April 20, 2022

Gareth Reece
Senior Plans Examiner
City of Mercer Island Community Planning and Development

RE: Permit 2109-150 Correction Comment Responses
Site Address: 9611 SE 72nd Street

1 EXTERIOR ELEVATION - SOUTH
1/4" = 1'-0"

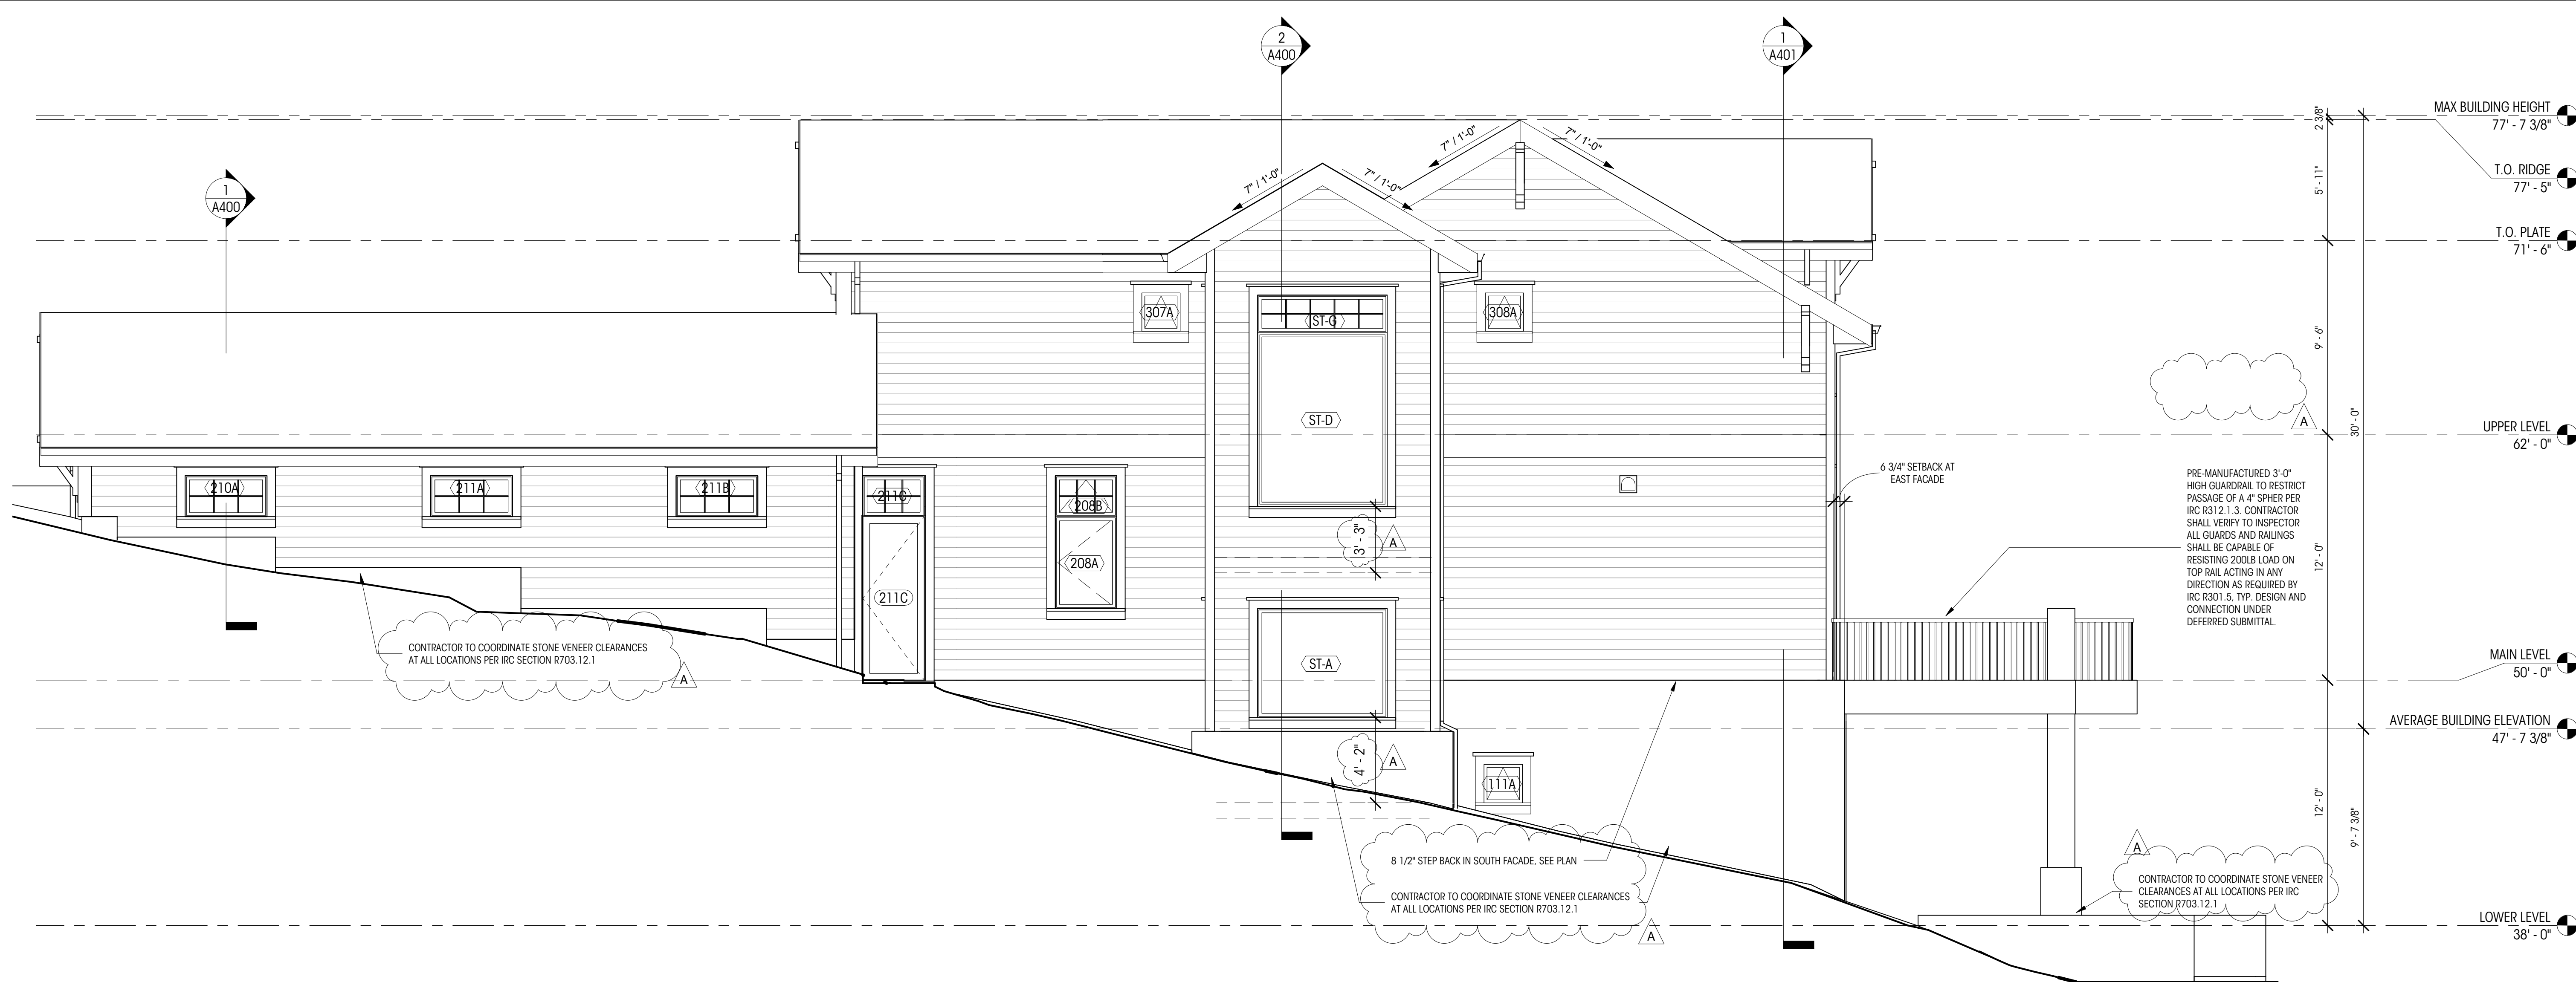
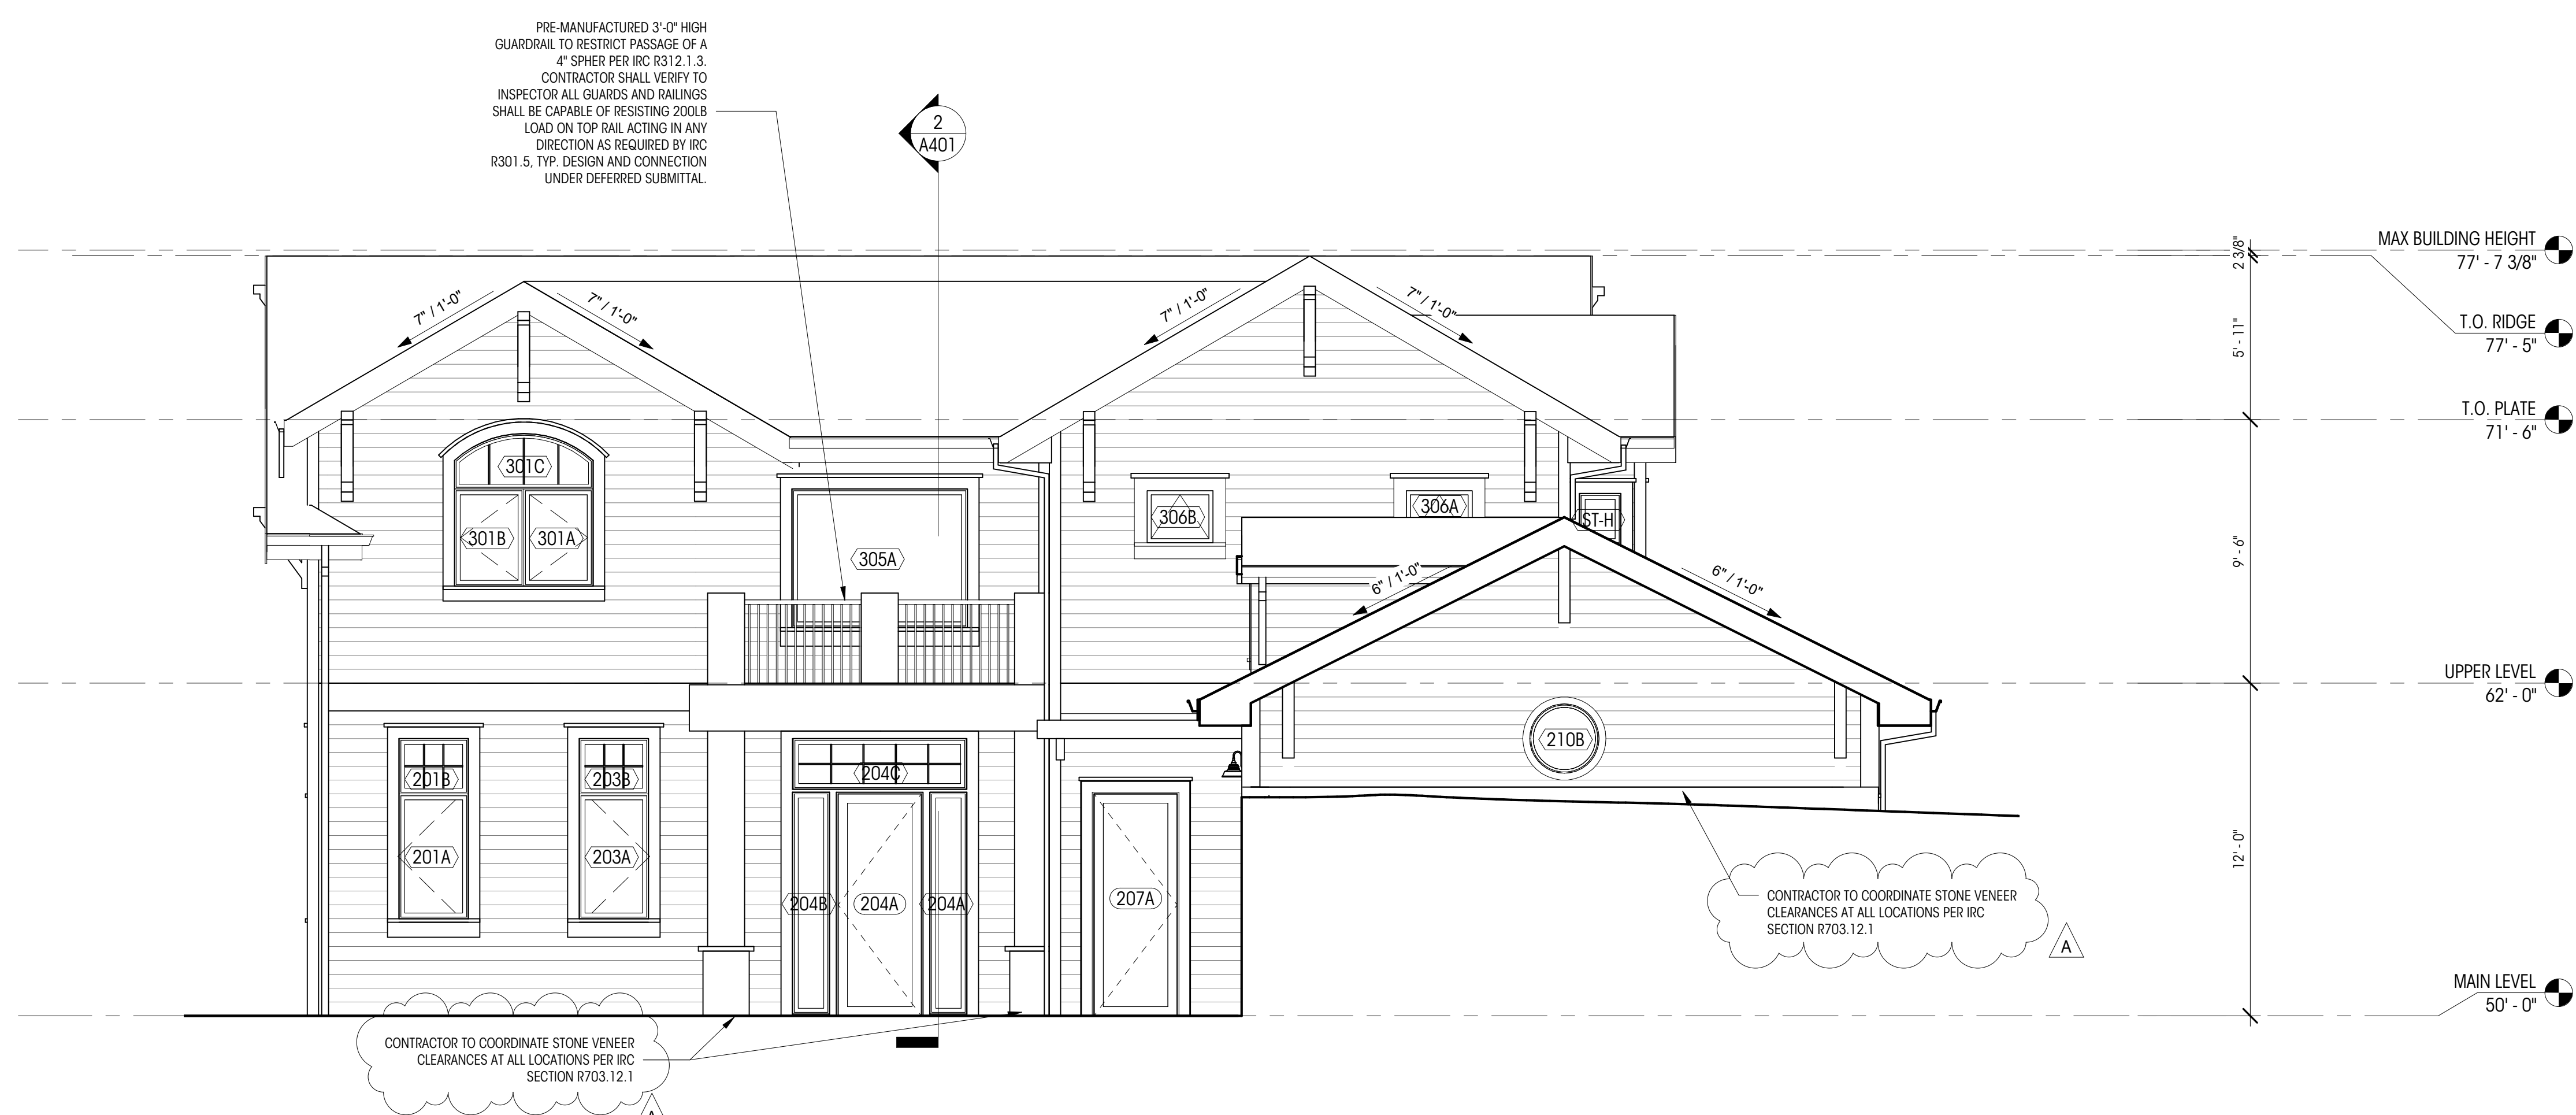
11. Adhered masonry veneer is required to have the following clearances per IRC R703.12.1: 4" minimum above the earth, 2" minimum above paved areas, and 1/2" minimum above exterior walking surfaces which are supported by the same foundation that supports the exterior wall. Please show these clearances on the drawings.

Response: Required clearances have been noted on exterior wall assemblies on sheet A700 and notes have been added to all exterior elevations on sheets A300 and A301.
